From: [REDACTED]
To: [Norfolk Boreas](#); [Norfolk Boreas](#)
Cc: [REDACTED]
Subject: Cawston Parish Council - Hearing 17th March
Date: 16 March 2020 16:51:55
Attachments: [Boreas Hearing 17 Mar draft.docx](#)

BOREAS HEARING 17 MARCH – CAWSTON PC draft comments

Cawston Parish Council wishes to submit the following for Deadline 6. This includes comments on D5 documents responding to the ExA’s written questions.

CAWSTON HIGH STREET - INTERVENTION SCHEME  
Scale 1:500

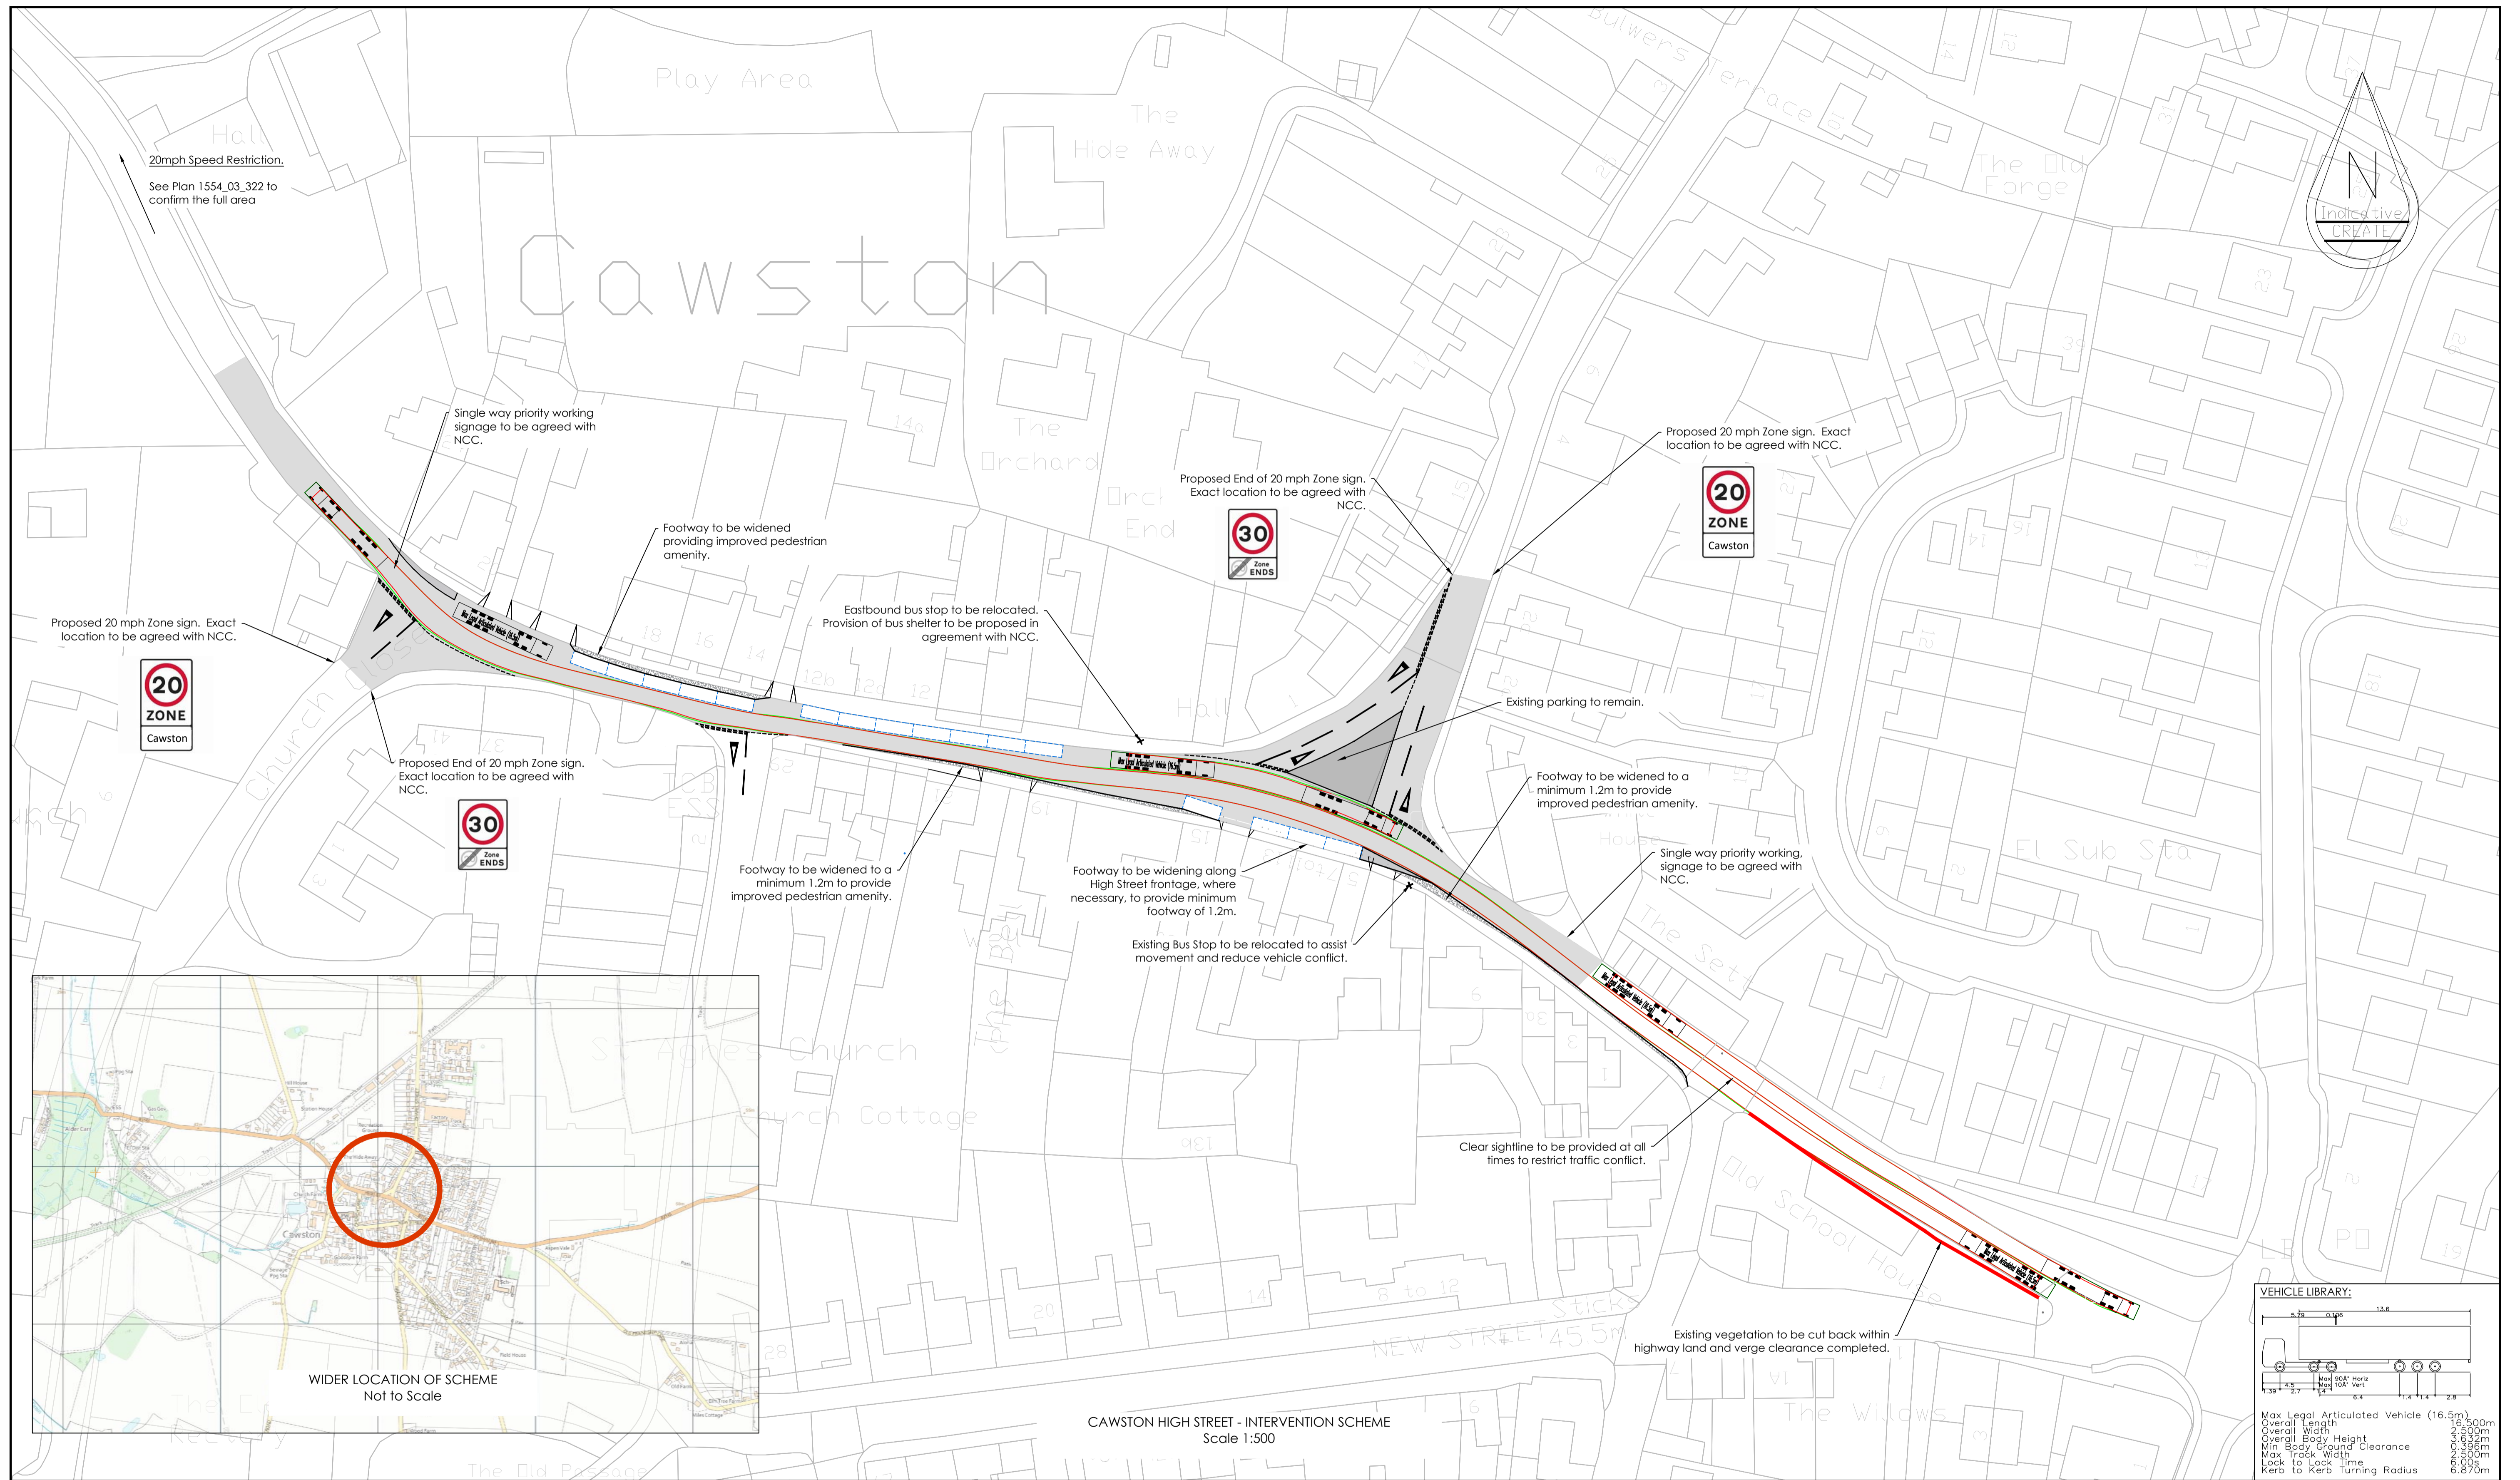
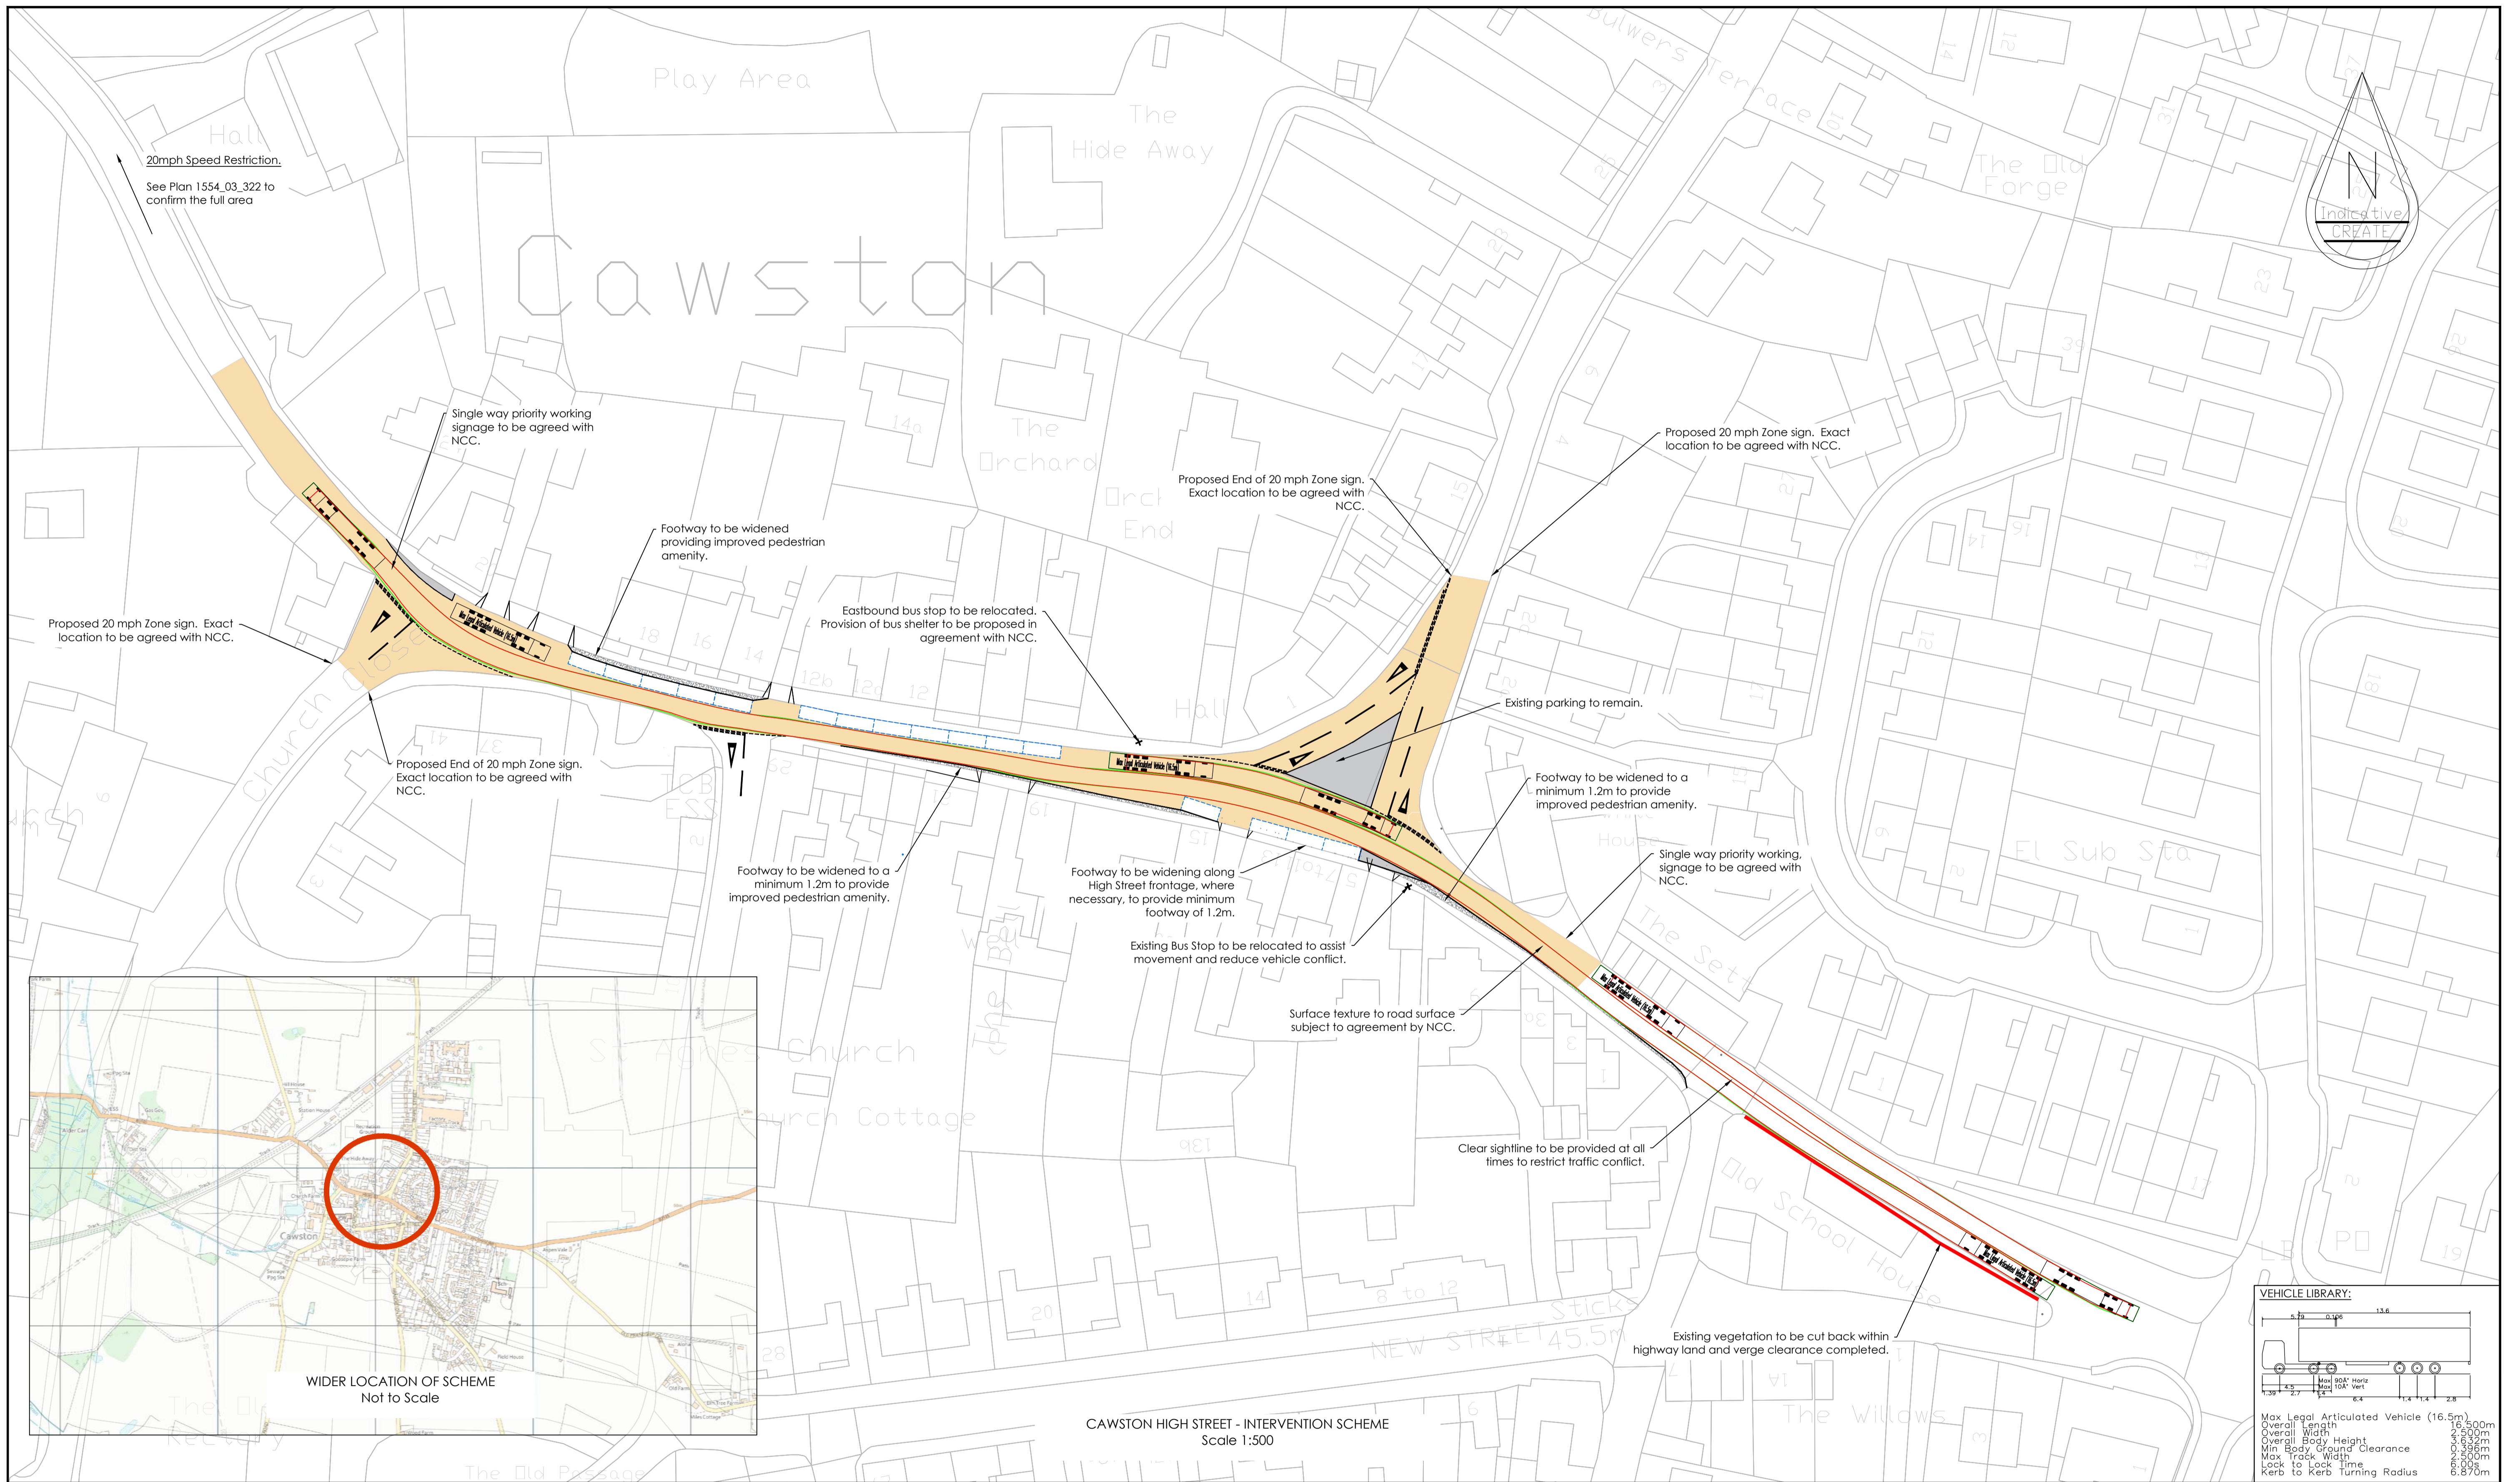
Firstly, we repeat our **assessment** that the B1145 through Cawston is completely unsuitable for the construction traffic proposed by the wind farm companies. No amount of selective manipulation of figures, averaging and smoothing can hide the basic facts:-

- At various points the road width is too narrow for larger vehicles to pass parked cars without overhanging, or mounting the **narrow pavement**. This is basic arithmetic.
- This has been observed at every one of the ASIs carried out by the three projects (Hornsea 3, Norfolk Vanguard and Boreas).
- It is also the experience of residents on a daily basis.
- Other pinch points are found all along the B1145 from Salle to the B1149, for example at the Salle Beck bends and Marriotts Way bridge to the west of Cawston, near to Aspen Vale and then close to the B1149 roundabout to the east.
- The effect of these points will be convoys of traffic arriving in the village centre from both directions, causing queues of stationary vehicles belching out fumes.

Returning to the latest Highway Intervention Scheme, we wait to hear the Norfolk CC verdict on the Road Safety Audit, but we consider it a clear **failure** as the Audit confirmed all of our observations while the Applicant's comments do not address the core issues.

- *The RSA confirms our points about dangers arising from sending this traffic through the centre of the village, due to the narrow road and pavements.*

- *Walking at 4km per hour (2.5 mph) a pedestrian covers 133 metres in two minutes. This means that every pedestrian can expect to encounter at least one of the Applicant's HGVs as they walk through the village.*
- *The RSA states "However, even with these points in mind, the Audit Team still perceive there to be a risk to pedestrians due to the narrowness of the footway and the proximity that HGVs will be to pedestrians."*

The geometry of Cawston High Street has remained unchanged for 250 years; if it was ever a "main distributor route", that would have been for horse drawn traffic. It is time to recognise this.
